# Salesbury Parish Council

**RE: Planning Application 3/2016/0114 Blue Trees, Copster Green, BB1 9EP**

Drawing
Proposed Garage and fence details

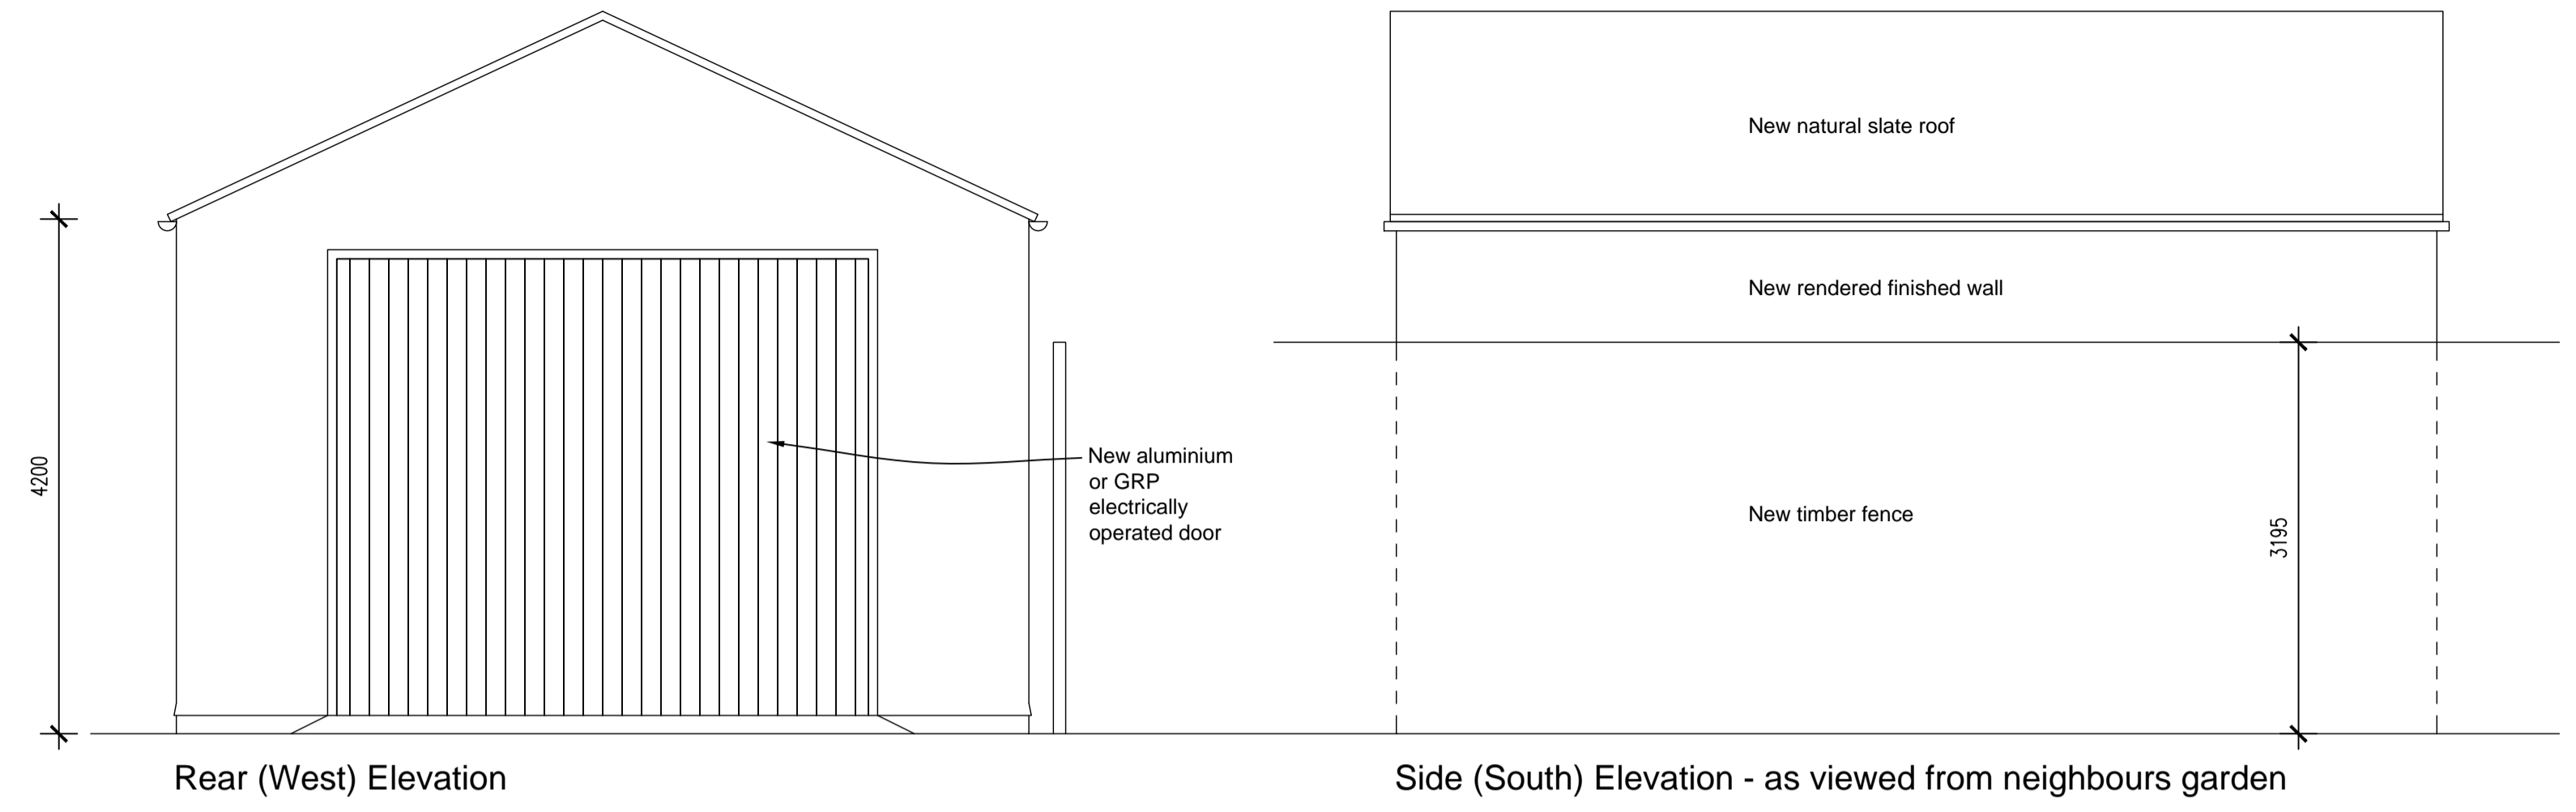
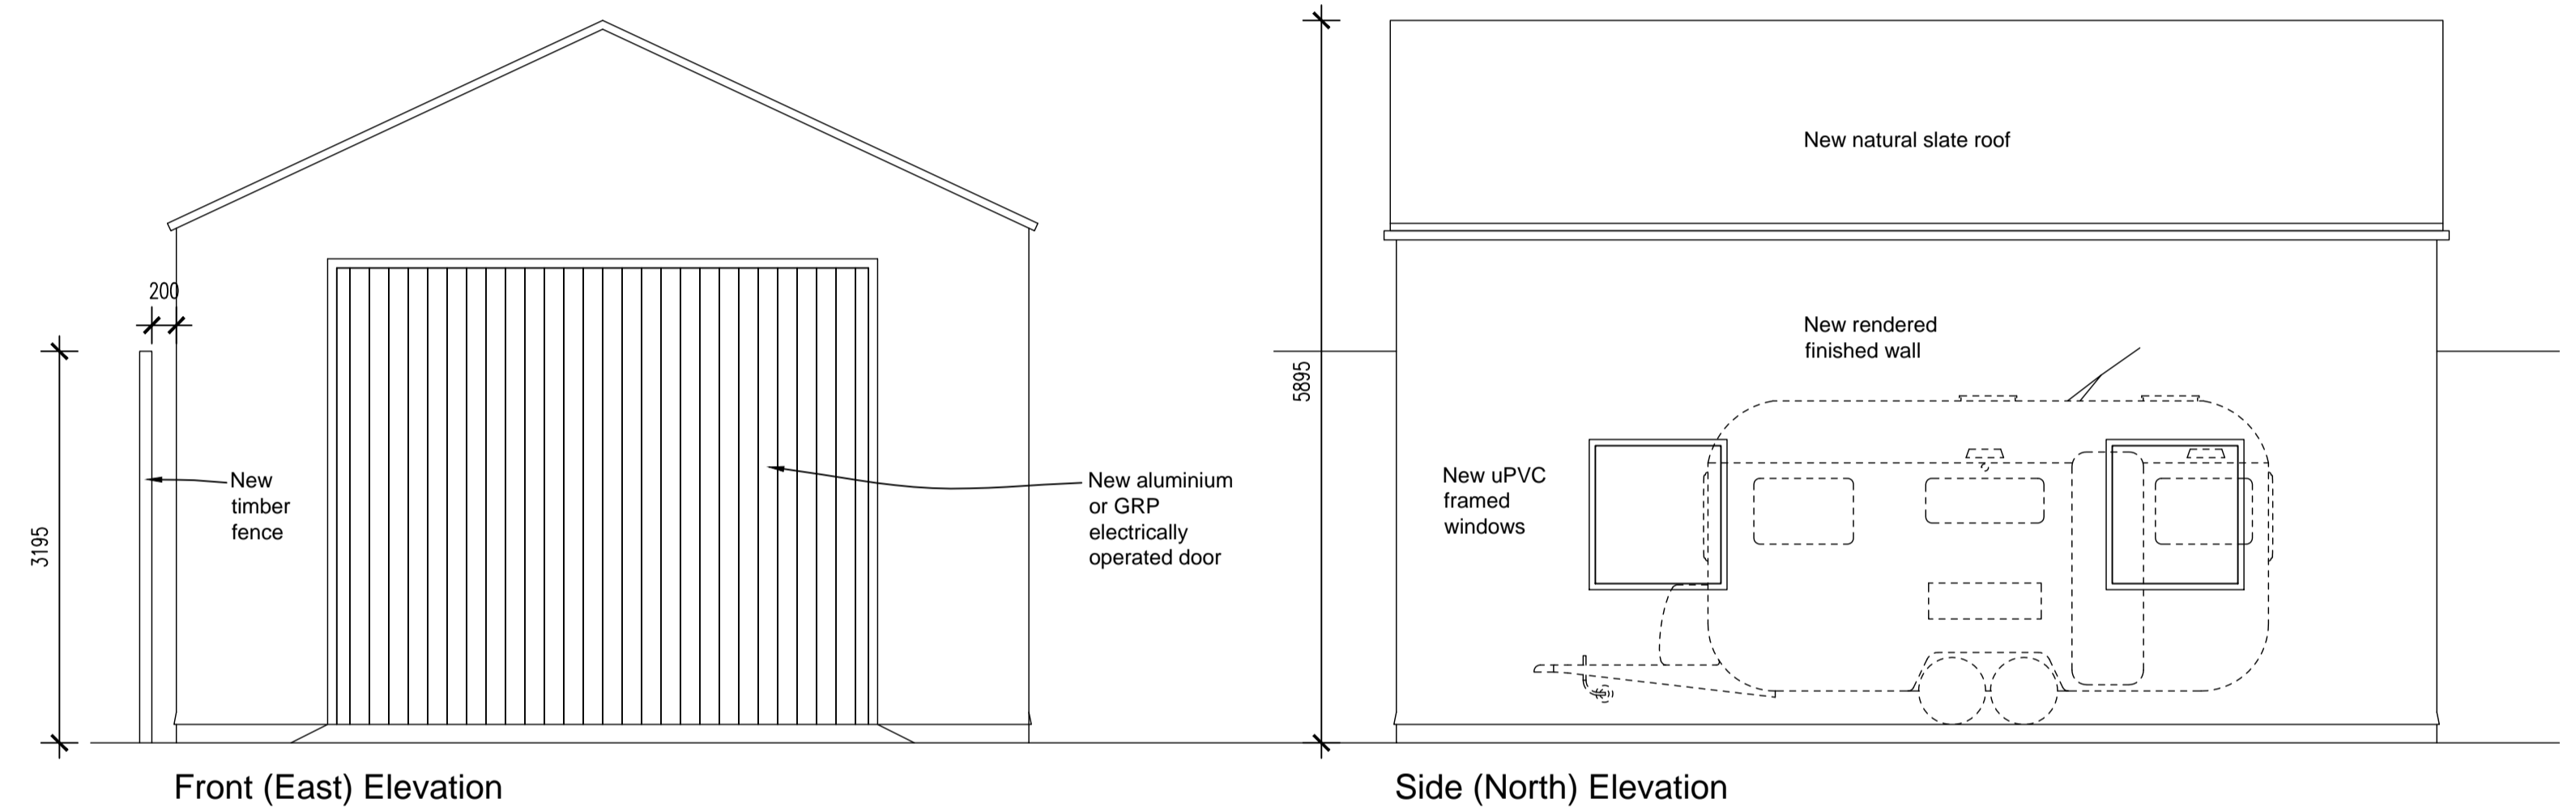
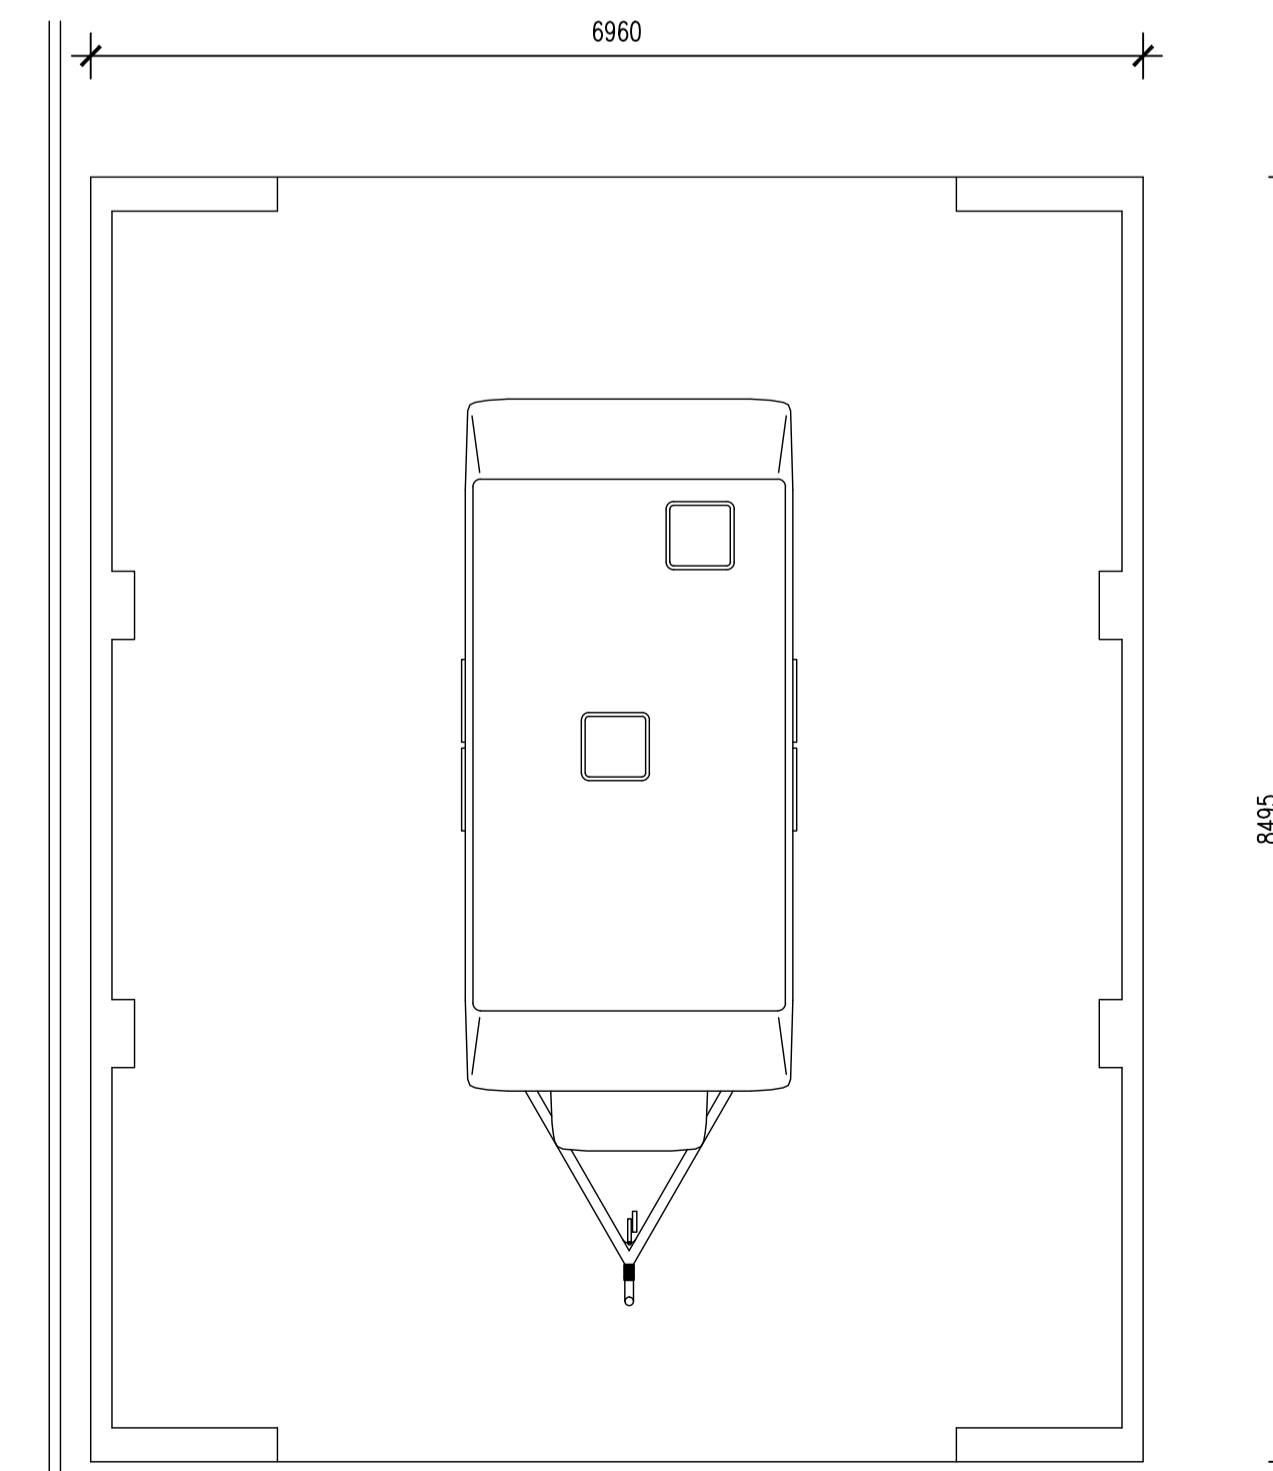
1. The proposals show a complete lack of a sympathetic approach to a rural environment;
2. The scheme would be best suited within an industrial estate;
3. The structure could not be maintained along the common boundary without access to the adjacent land;
4. The proposals have no aesthetic merit to the locality/ landscape or environs;
5. The timber fence is over ten feet in height and would be an eyesore;
